**Consultation Response from KC,
Trees**

2025/93313 68, Oxford Road, Dewsbury, WF13 4EH

Erection of two storey front extensions with balcony, two storey rear extension, single storey side extension and balcony to rear roof slope with associated alterations

Date Responded:02/04/2026

Tree Constraint Plan

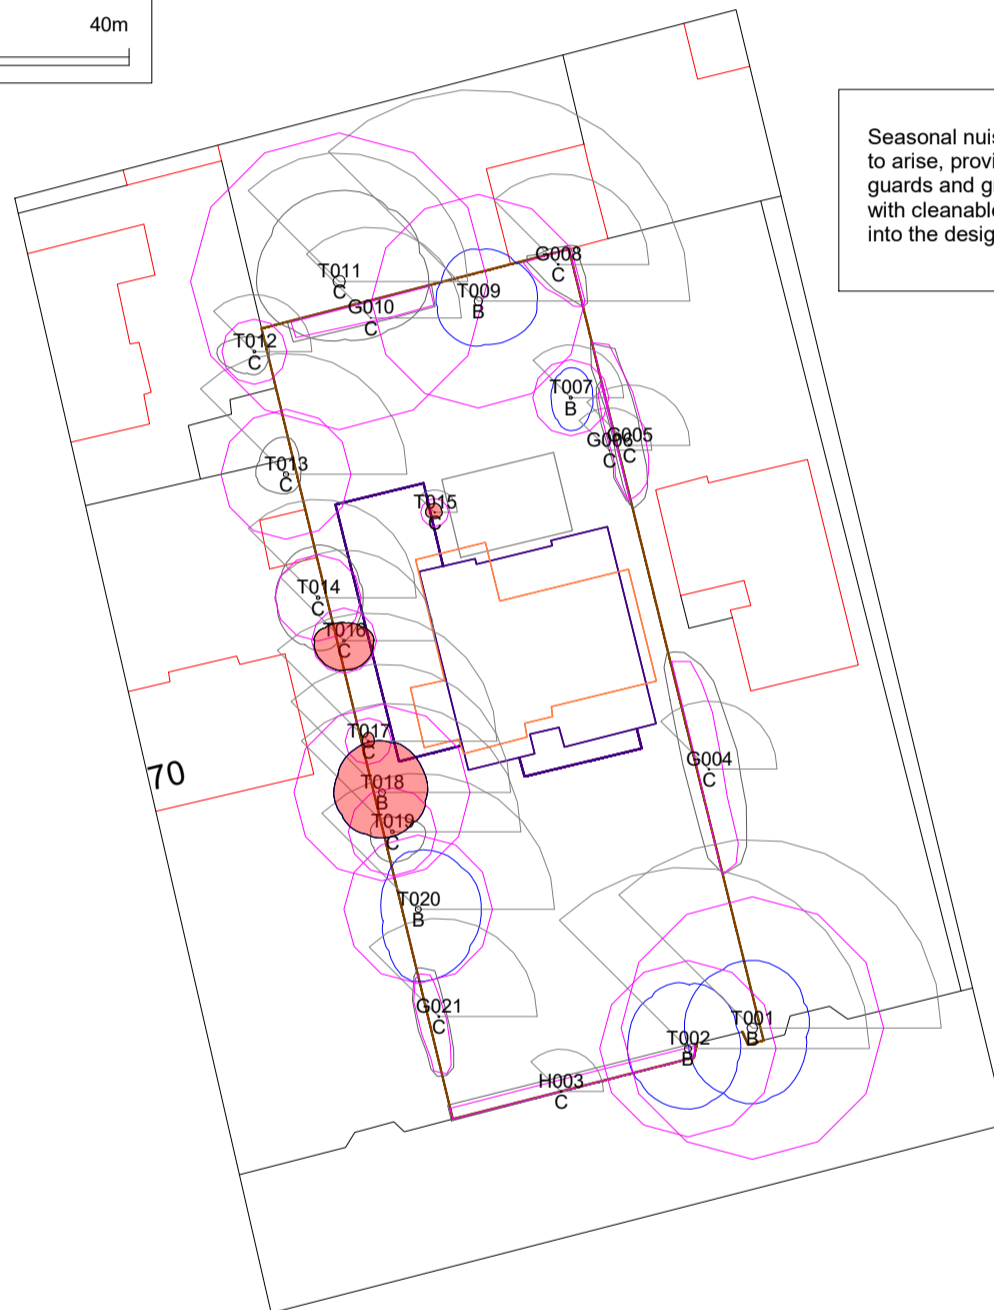
The scale of the new structure is too large to be accommodated with the boundary vegetation. The removal of Category B T018, Category C T016 and T017 to facilitate the development would constitute a loss of amenity value to the surrounding area. These removals also would impact the privacy and enjoyment of the neighbouring property, as the trees along the eastern boundary of the site currently serve as attractive screening vegetation between the two properties.

Secondly, the new structure is sited immediately at the edge of the canopy and RPA of the neighbour's willow tree T14. It would be necessary to routinely manage the canopy to prevent damage to the proposed structure, potentially damaging the health of the offsite tree over time, whilst presenting a nuisance and ongoing cost to the occupier of No.68. Buildings and other structures should be sited allowing adequate space for a tree's natural development, with due consideration given to its predicted height and canopy spread.

Please note that it would be necessary carry out soil investigations to determine the plasticity of the soil to specify the required depth of the foundations to be able to withstand this proximity to a willow tree. Willows are a high-water demand species and as such can have a significant effect on soil moisture which can lead to clay shrinkage.
